From: [Borough Planning](#)
To: Aiden.Architecture@outlook.com
Cc: [PScan1](#)
Subject: RE: Invalid Letter 22/02027/F
Date: 11 January 2023 09:34:31
Attachments: image002.png
image003.png
image004.png
image005.png

Ref: 22/02027/F

Rev	Description	Date
<b>Client</b>	: Mr & Mrs Cooper	
<b>Job title</b>	: Anvil, Main Road, Wisbech, PE14 9JR	
<b>Drg</b>	: Proposed Elevations	
<small>scale</small>	1:100	<small>date:</small> Oct 2022
<small>@ A3</small>		<small>drg. no.</small> A400-09

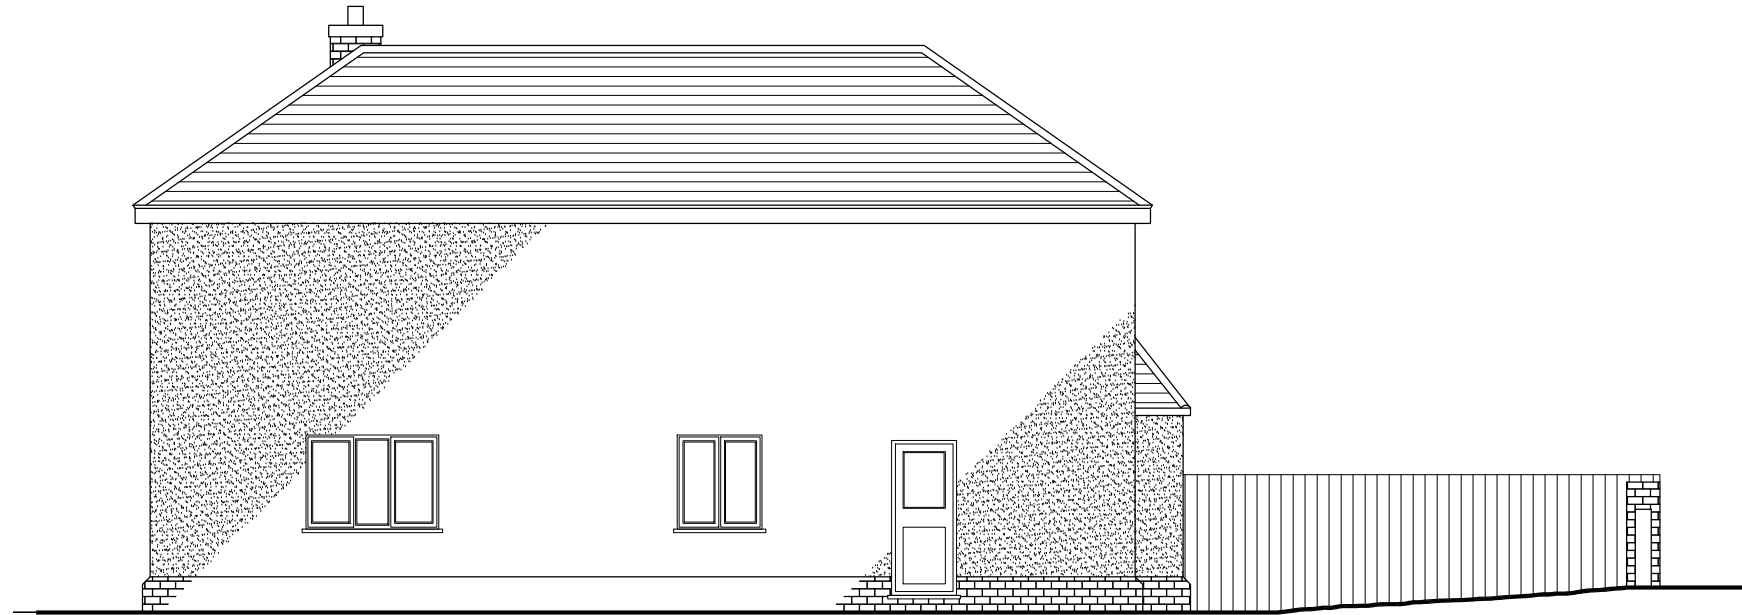
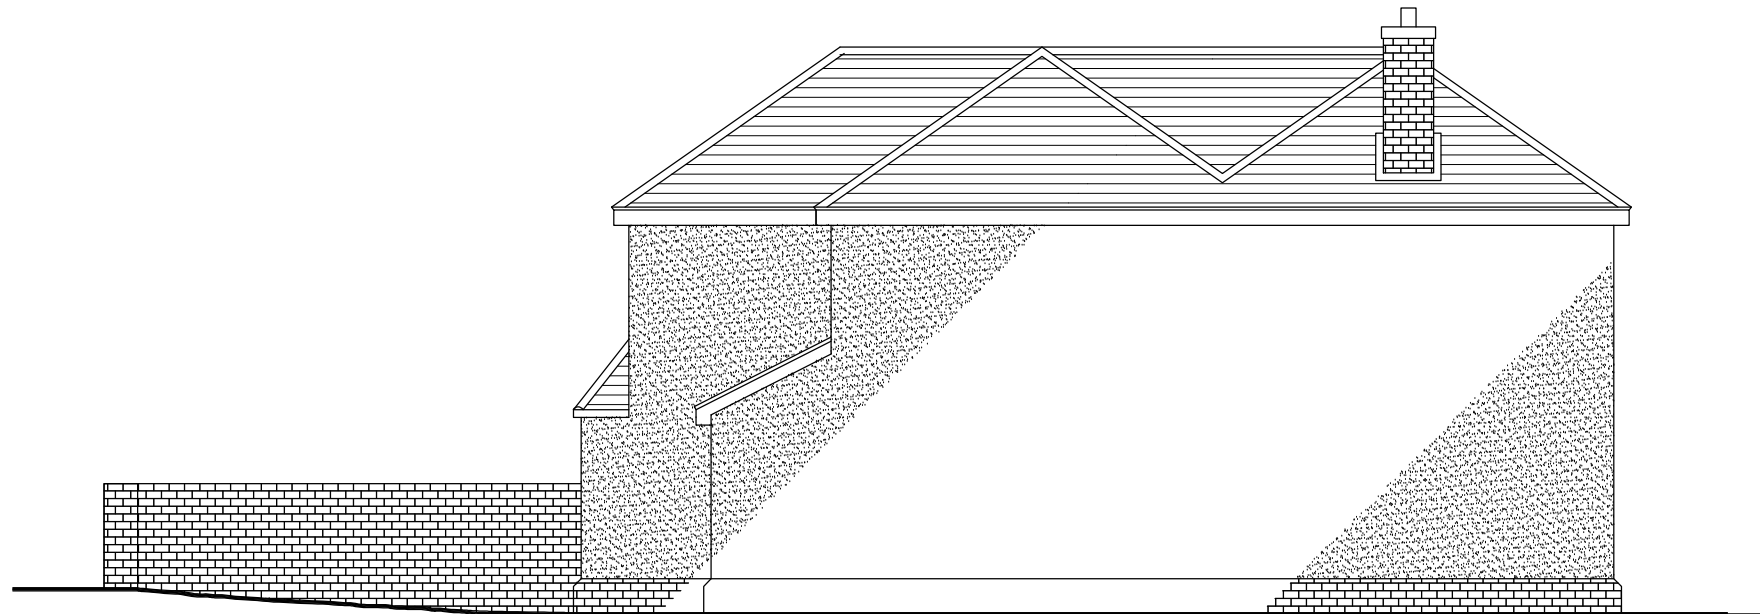
Thank you for your email and attachments. I have reviewed the documents submitted and have accepted the new information regarding the dropped curb. However I have noticed that you appear to have labelled all of the elevations as front. Please could you name each elevation accordingly i.e. front, rear, side etc. This will help to avoid confusion and possible delays when the application reaches the planner.
